**Case Officer:** Imogen Hopkin

**Applicant:** Miss Joannafey Mills

**Proposal:** Demolition of existing dwelling and erection of a replacement detached dwelling including the partial removal of existing outbuildings, replacement outbuildings, proposed swimming pool and associated landscaping

title	THE BARN & BYRE PROPOSED ELEVATIONS II	
project	New Barn Farm	
client	J. Mills	
scale	1:50 @ A1 / 1:100 @ A3	status Planning
date	Nov 2022	job number 359
drawn	FP	drawing number 014/*
checked	CF

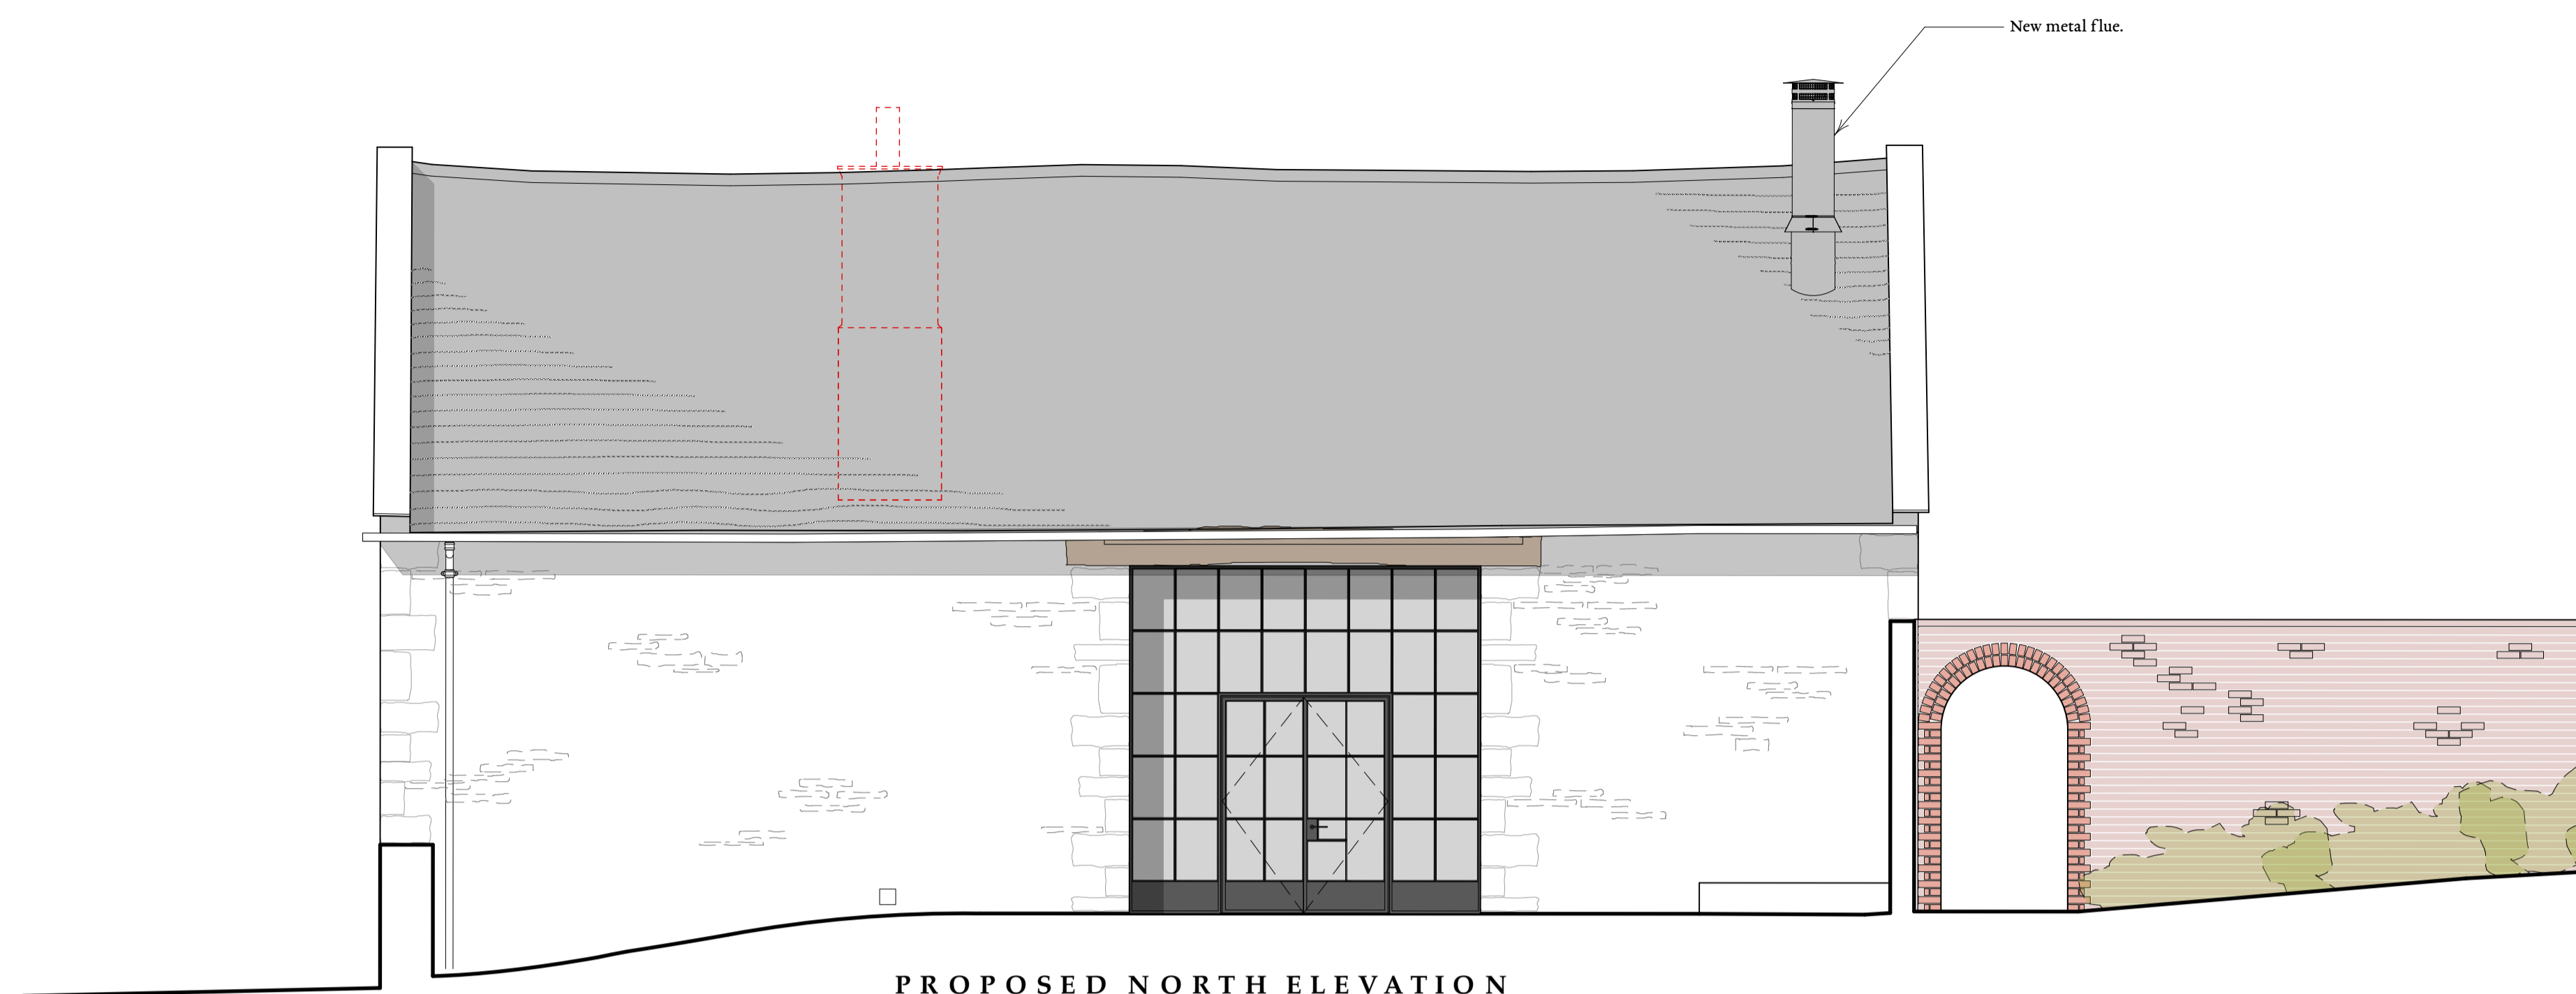
- 8.16. The accommodation provided within the barn building is an entertaining area with kitchen and toilets, pool equipment room and pool plant room. The accommodation is considered to be ancillary to the use of the main dwelling, and would therefore be acceptable to be approved, subject to a condition ensuring the building could not be converted, sold or sub-let.
